Development Review Board 9/12/07 Agenda Item #12
Sketch Plat: Lot 2, Rancho Guadalupe Subdivision

DRB CASE NO/PROJECT NO: 1004891

Sketch Plat

RE: Lot 2, Rancho Guadalupe/sketch

# REPLAT OF TRACTS 12-b, 30, 31, 32, 33, 114A, 114b1, 113, 114b3 AND A WESTERLY PORTION OF TRACT 13 ALL WITHIN M.R.G.C.D. PROPERTY MAPS No. 31 AND 32 SECTIONS 31 AND 32; TIIN, R3E, N.M.P.M. CITY OF ALBUQUERQUE BERNALILLO COUNTY, NEW MEXICO NOW COMPRISING RANCHO GUADALUPE AUGUST, 1979

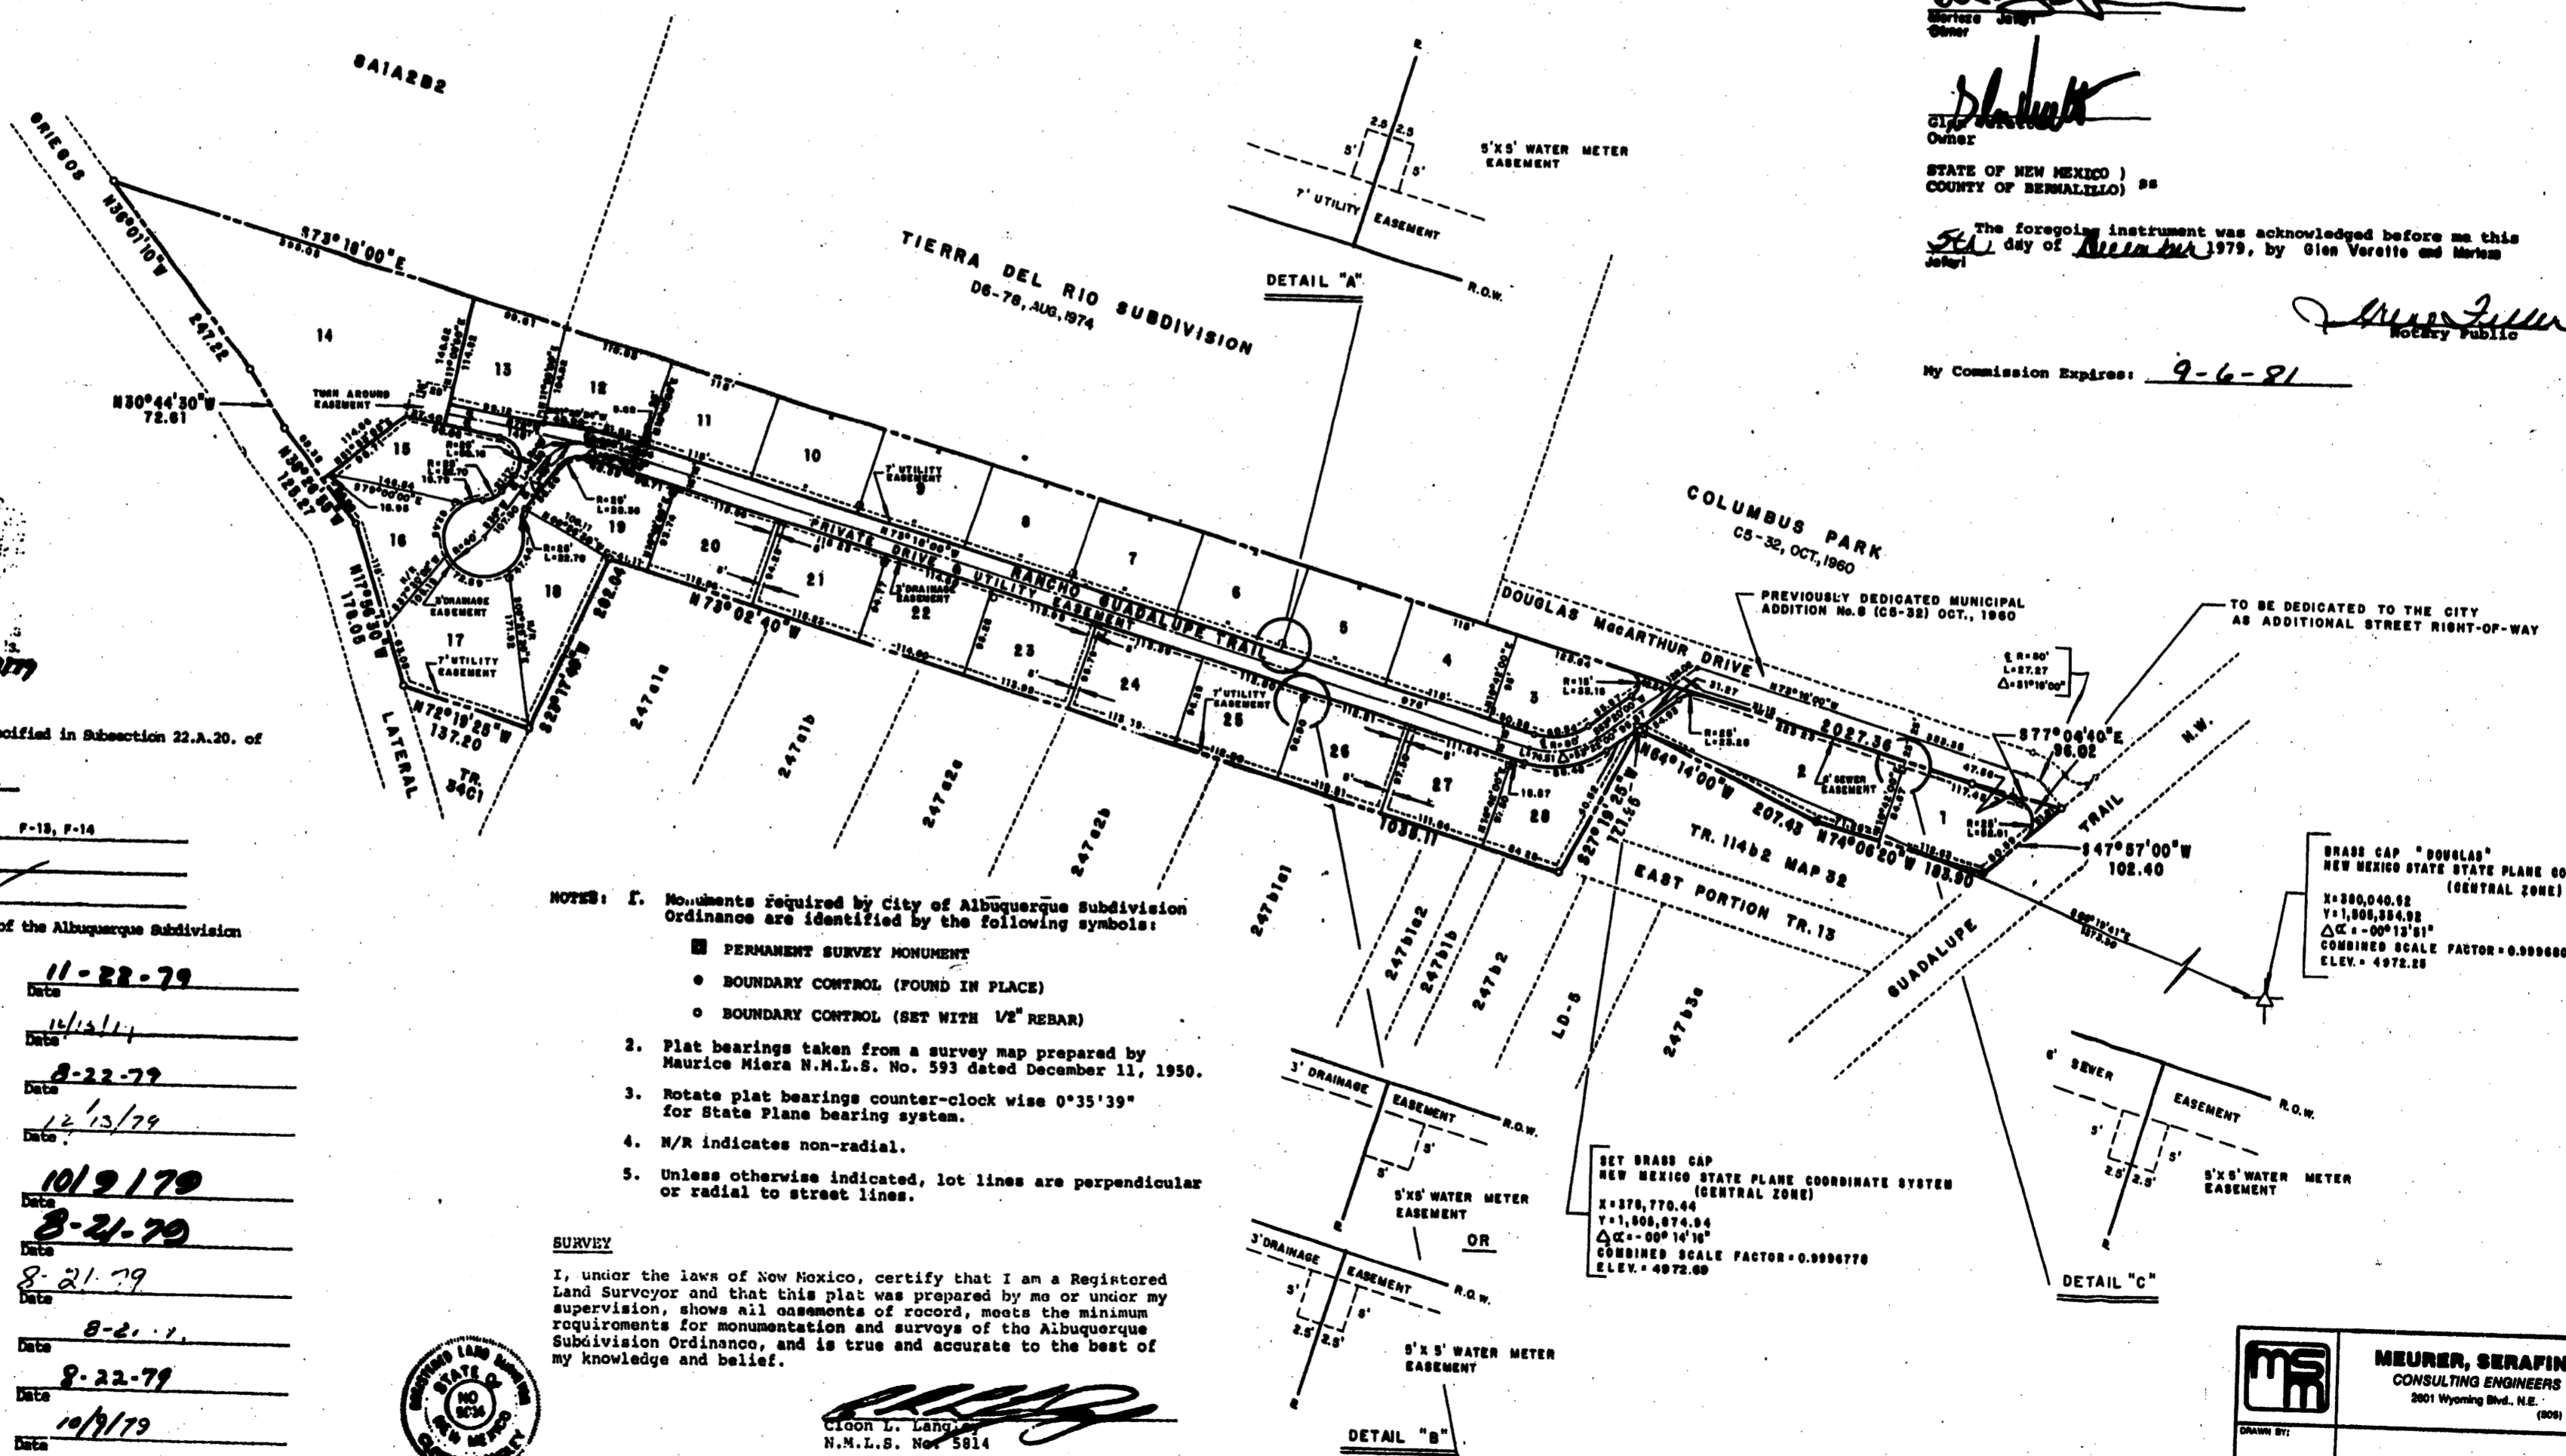
It appears that the proposed subdivision request will not meet the minimum lot size requirement of 10,890 square feet of the City of Albuquerque Comprehensive City Zoning Code.
